Epping to Thornleigh Third Track Proposal. Application number SSI 5132.

Name(s): EDWARD KOK

I/we object to the Epping to Thornleigh Third Track Proposal and consider that the EIS is inadequate and does not address the full impact of this proposal. It will cause untold damage to the health of residents and to the fabric of the Beecroft Cheltenham Heritage Conservation Area. Do not approve this project, reconsider the alternatives and protect the community.

Figure 5.5 Artist's impression of new elevated concourse at Cheltenham Station looking south from The Crescent (indicated circle)

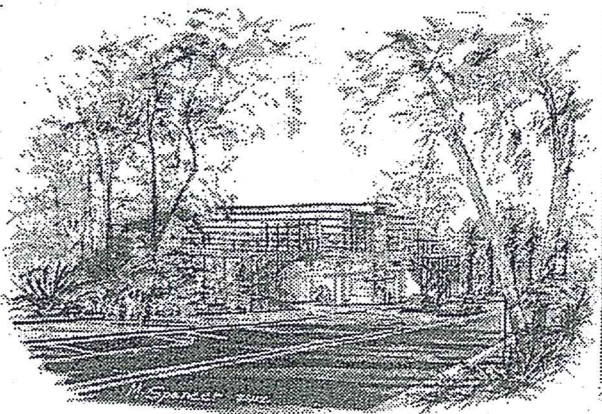
- The proposed redevelopment of Cheltenham Station shows no regard for the HCA. The visual impact of the proposed 13m high glass and steel concourse is totally unacceptable in this HCA.

Concept design drawing of proposed changes to Beecroft Station (Parsons Brinckerhoff 9/3/12). Former side platform shaded in pink.

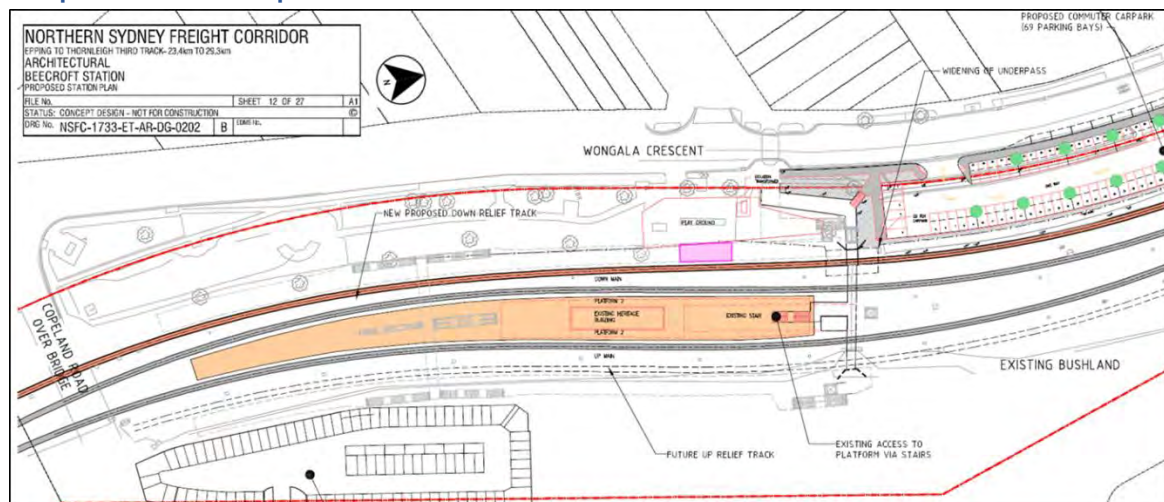
- There has been inadequate assessment of the project's impact on the fabric of the Beecroft Cheltenham Heritage Conservation Area (HCA).
- The plan given for Beecroft Railway station Precinct is vague. The relationship to the trees, playground and original 1895 platform located south of the present station is not shown. A fourth track is shown on the eastern side. The plan does not include urgently needed lifts to allow disabled access at Beecroft Station.

- Beecroft Station Gardens have a heritage listing with Hornsby Council but the impact on them has not been adequately addressed. No arborist's report is given for the trees which will be removed.
